SPR EA1N and EA2 PROJECTS

RESPONSE TO LETTERS FROM THE DEPARTMENT OF BUSINESS ENERGY AND INDUSTRIAL STRATEGY DATED 20 DECEMBER 2021

FLOOD RISK COMMENTS

Interested Party: SASSES **PINS Refs:** 20024106 & 20024110

**Item 3 – Grove Road (proposed haul road/cable route crossing the public highway (Work No 26)).**

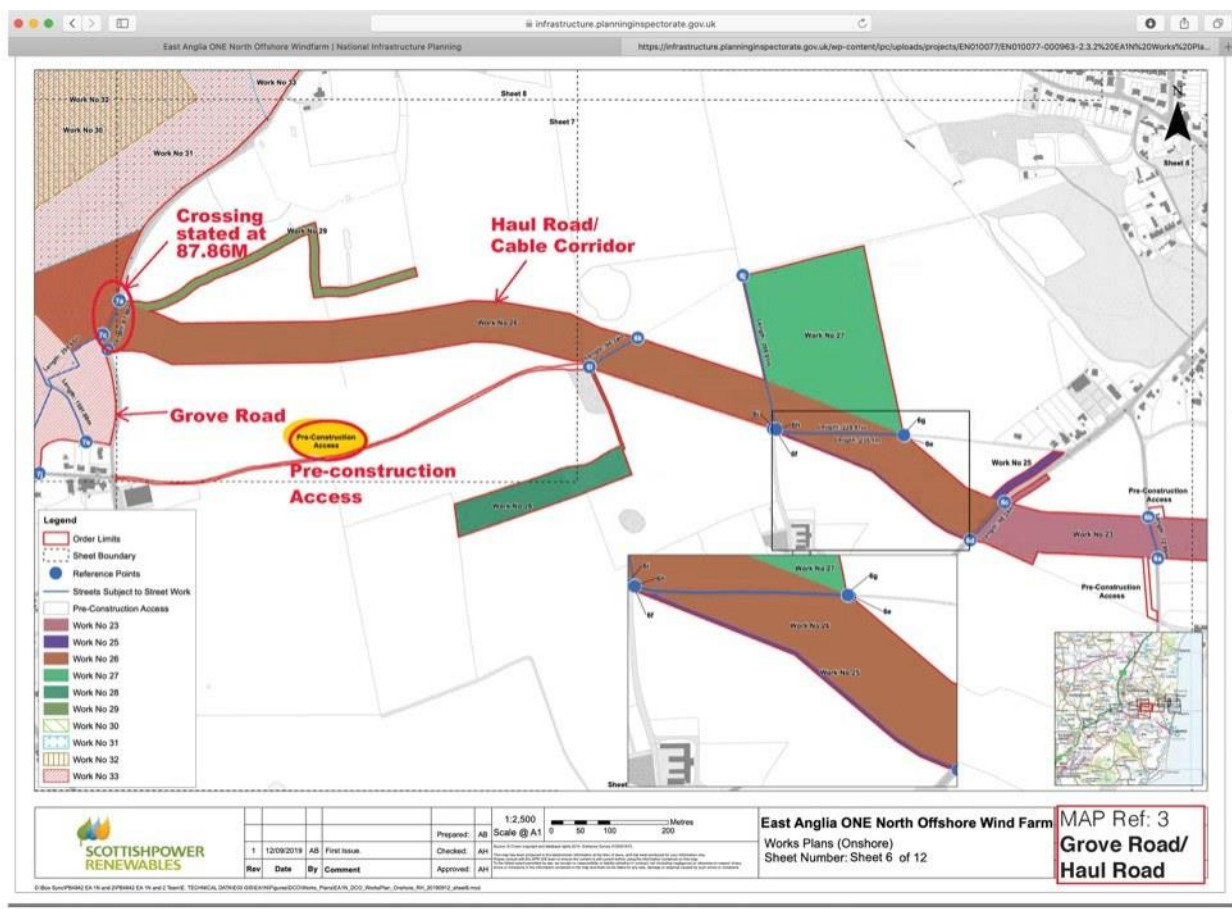
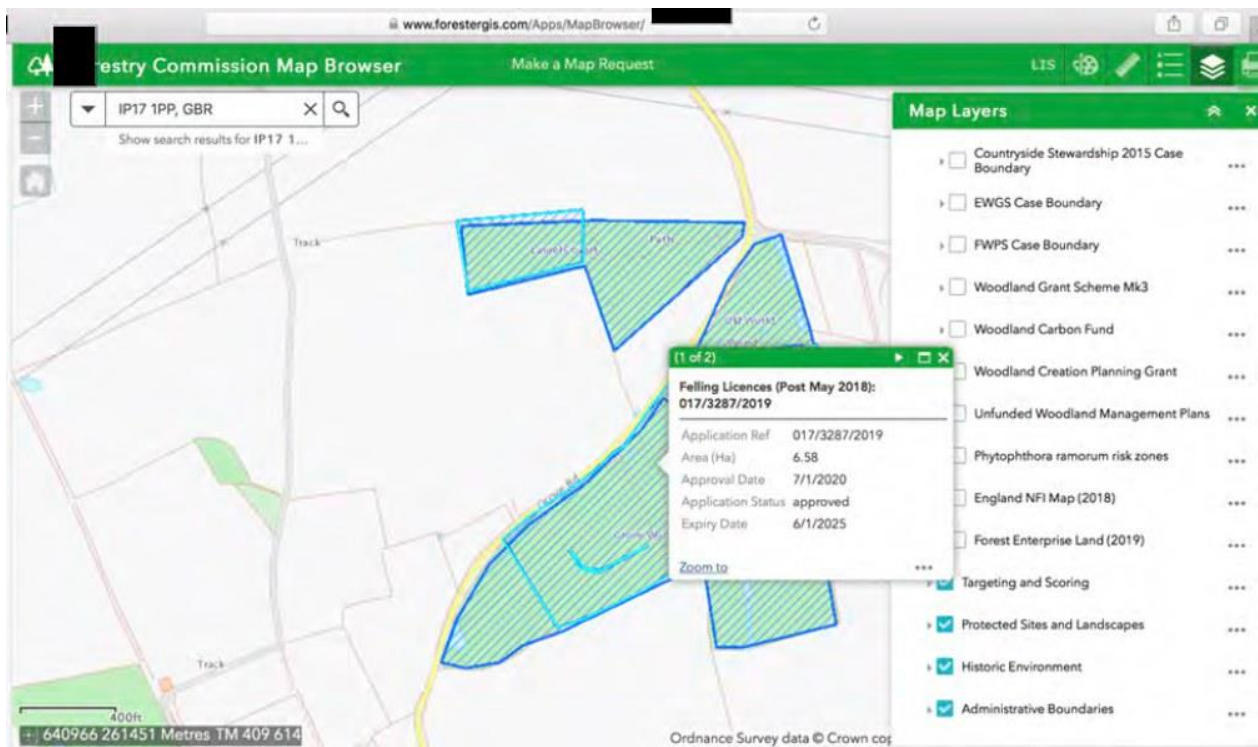
13. Another source is the agricultural land to the east of Grove Road which is of serious concern during the construction phase because this is the location of the cable route and haul/access road where it approaches, crosses and joins the substations construction site from the east to the west of Grove Road (Work No. 26) - see Works Plan attached at Appendix 4.

14. The Applicants, in separating surface water flood risk from the substations construction site from surface water flood risk from the cable route and haul/access road, did not assess the combination of the flood risk from these two sources of flood risk to Friston. There is attached at Appendix 3 images, taken during the flood event in October 2019, showing the area which is a source of surface water flows from the east of Grove Road and the surface water flooding along Grove Road to Friston. The location and direction in which those images were taken are
